CITY OF ALBUQUERQUE

March 19, 2018

**Re: Hotel Albuquerque NW Parking Lot
Traffic Circulation Layout – Not Required**
Engineer's Stamp dated 03-07-18 (J13-D066)

SITE PLAN
1" = 50'-0"
0 50' 100'

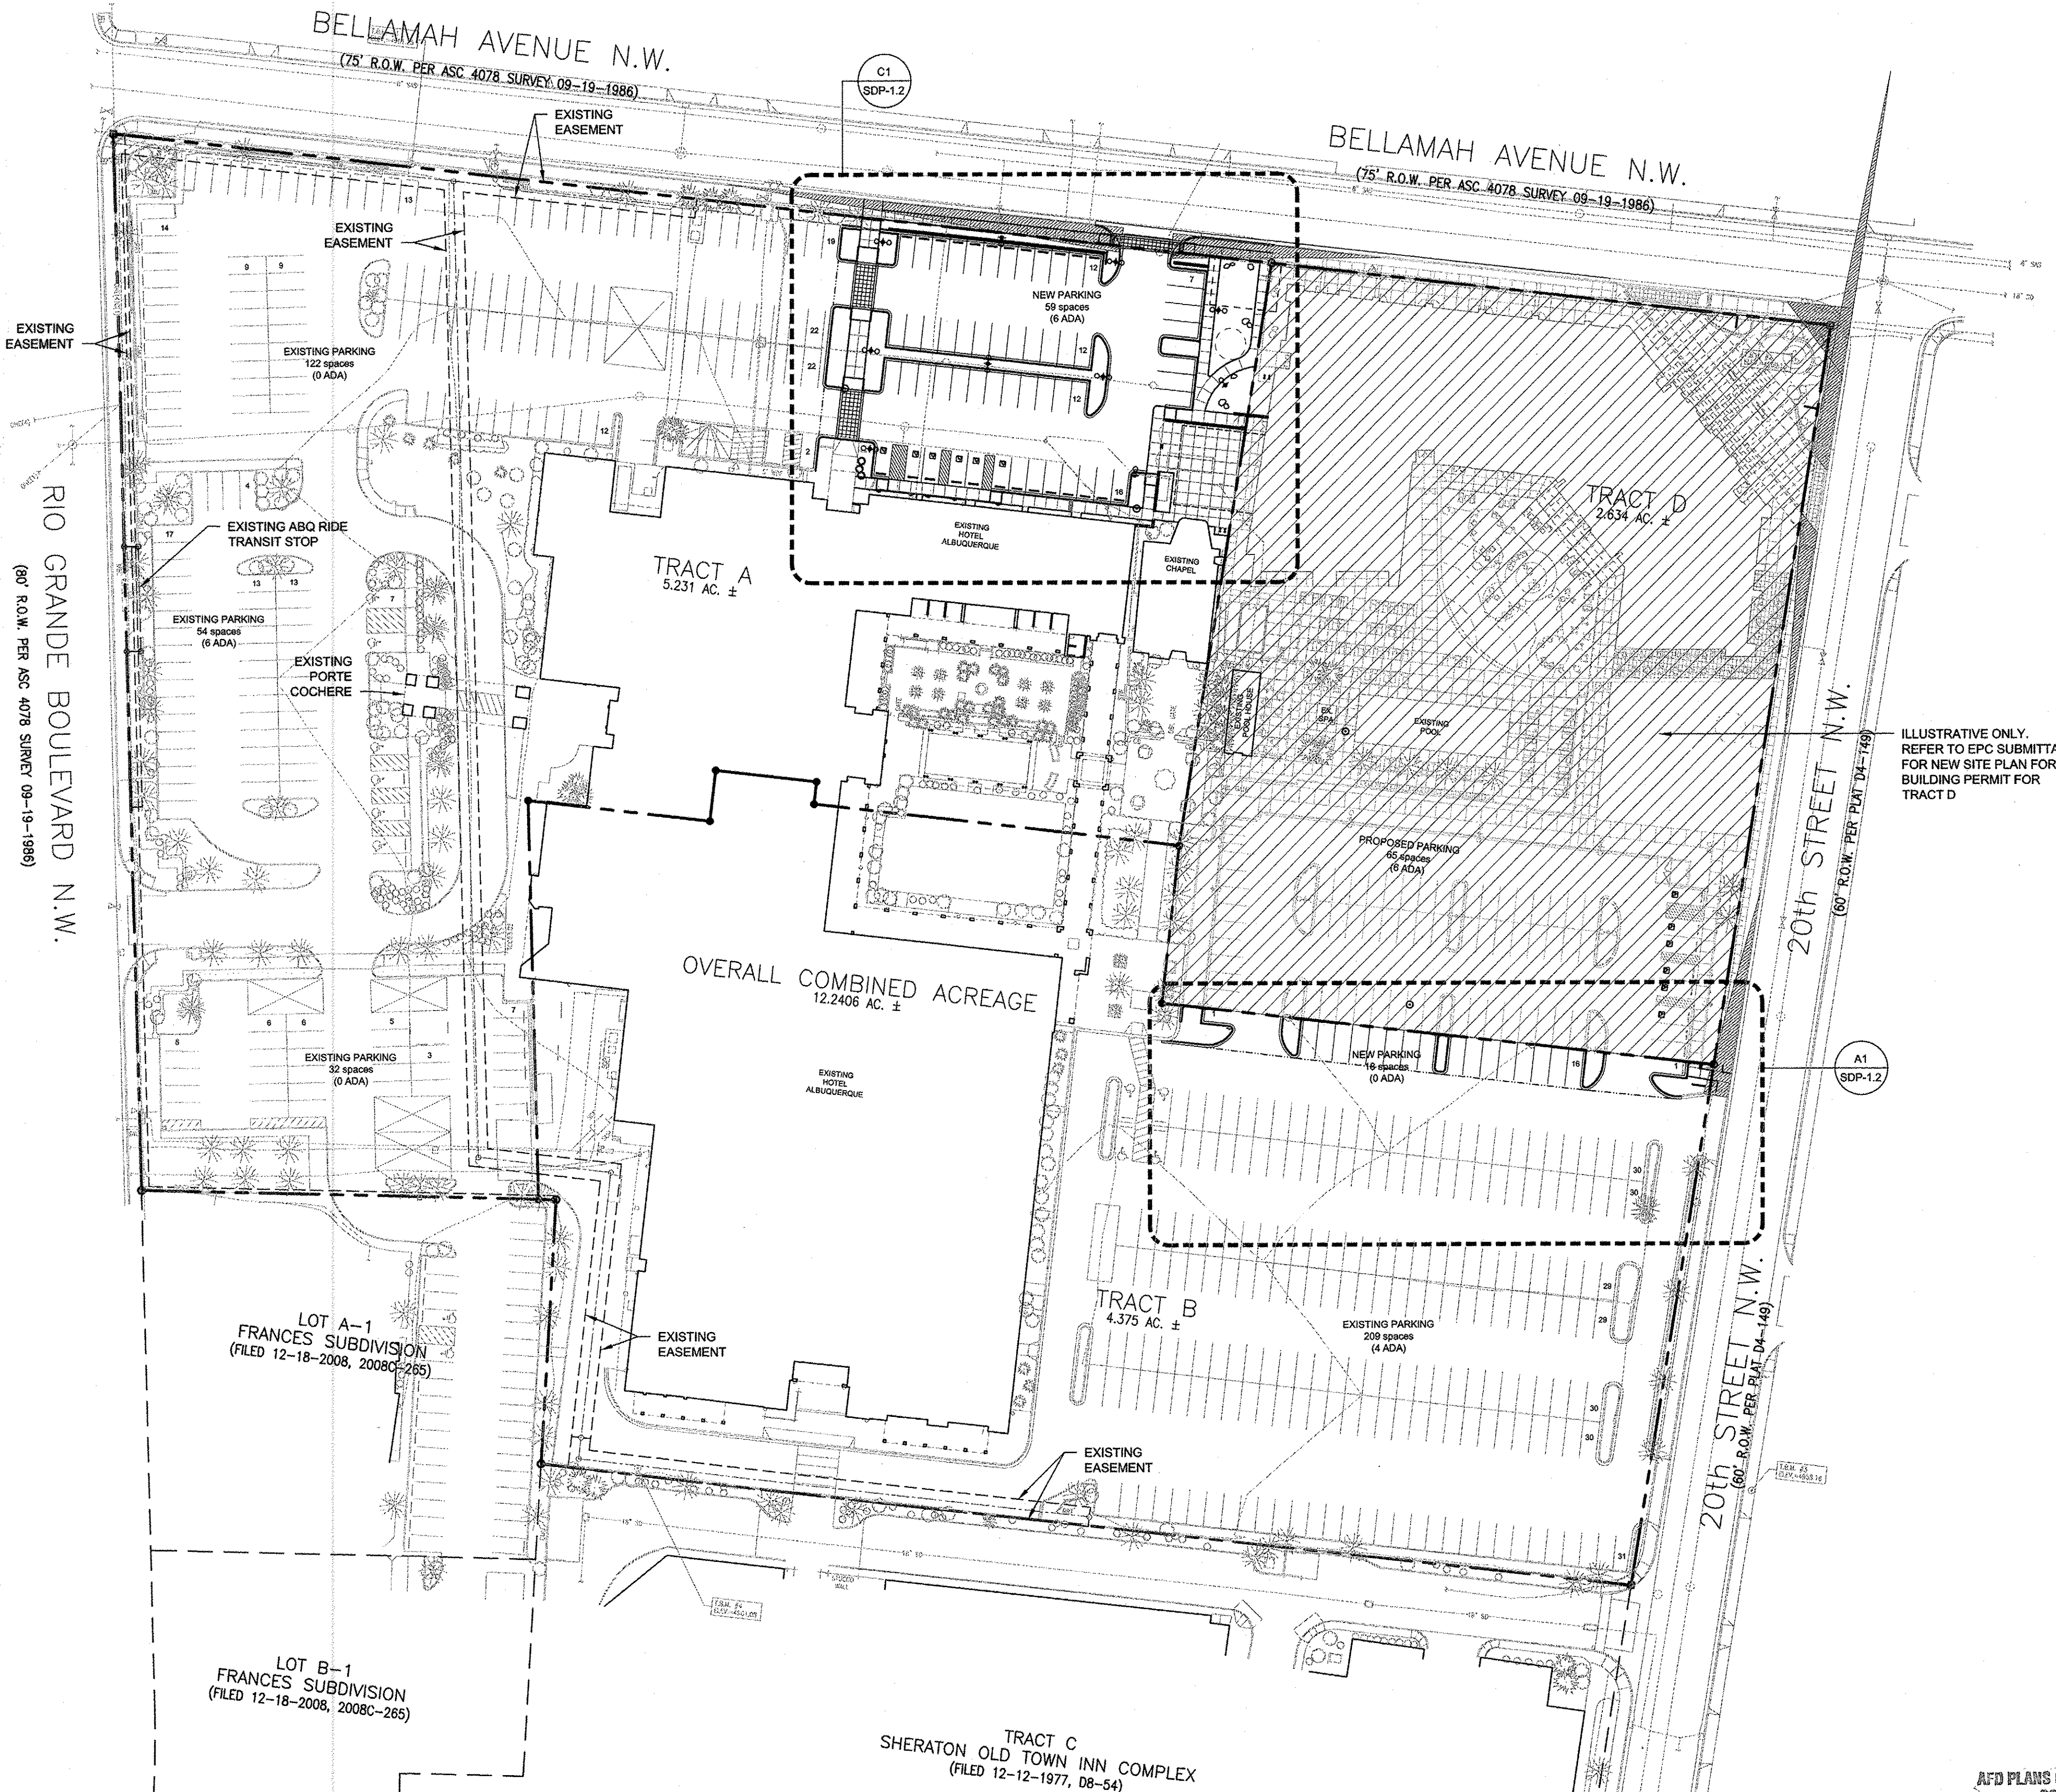
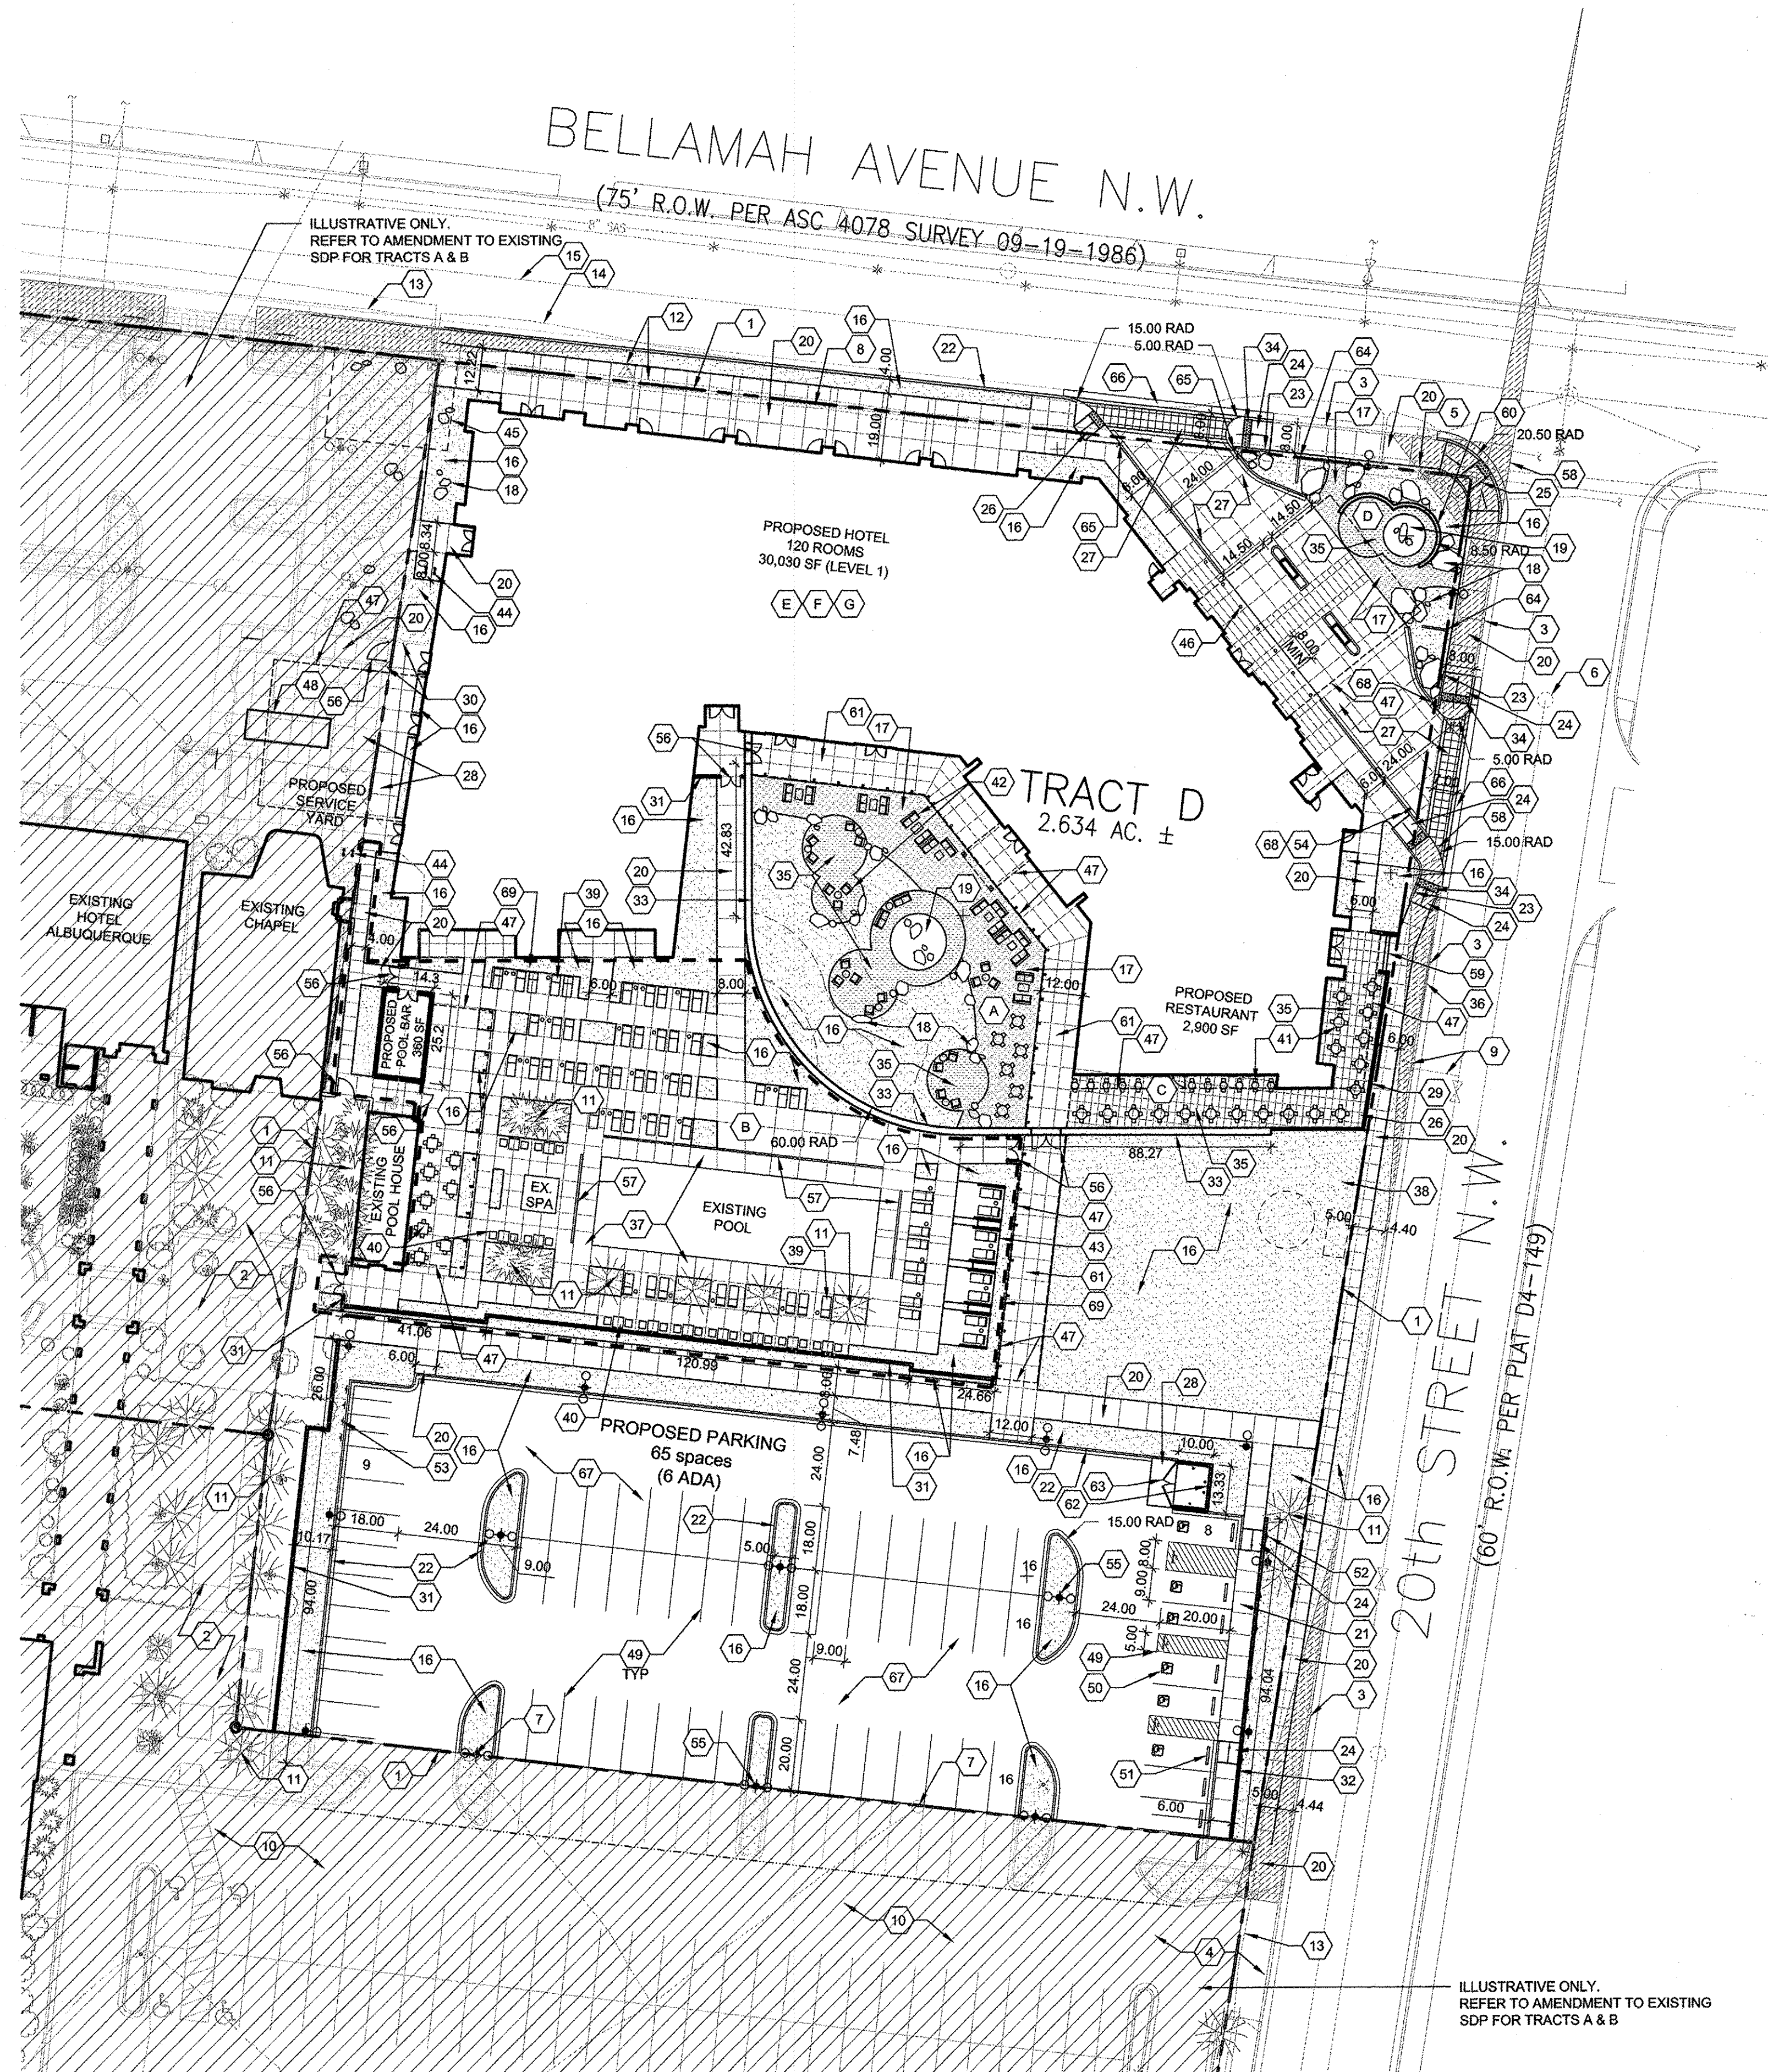
1. Motorcycle parking spaces shall be designated by its own conspicuously posted upright sign, either free-standing or wall mounted per the zoning code.
2. Please dimension all existing parking spaces.
3. Some drive aisles are not dimensioned, please add dimensions.
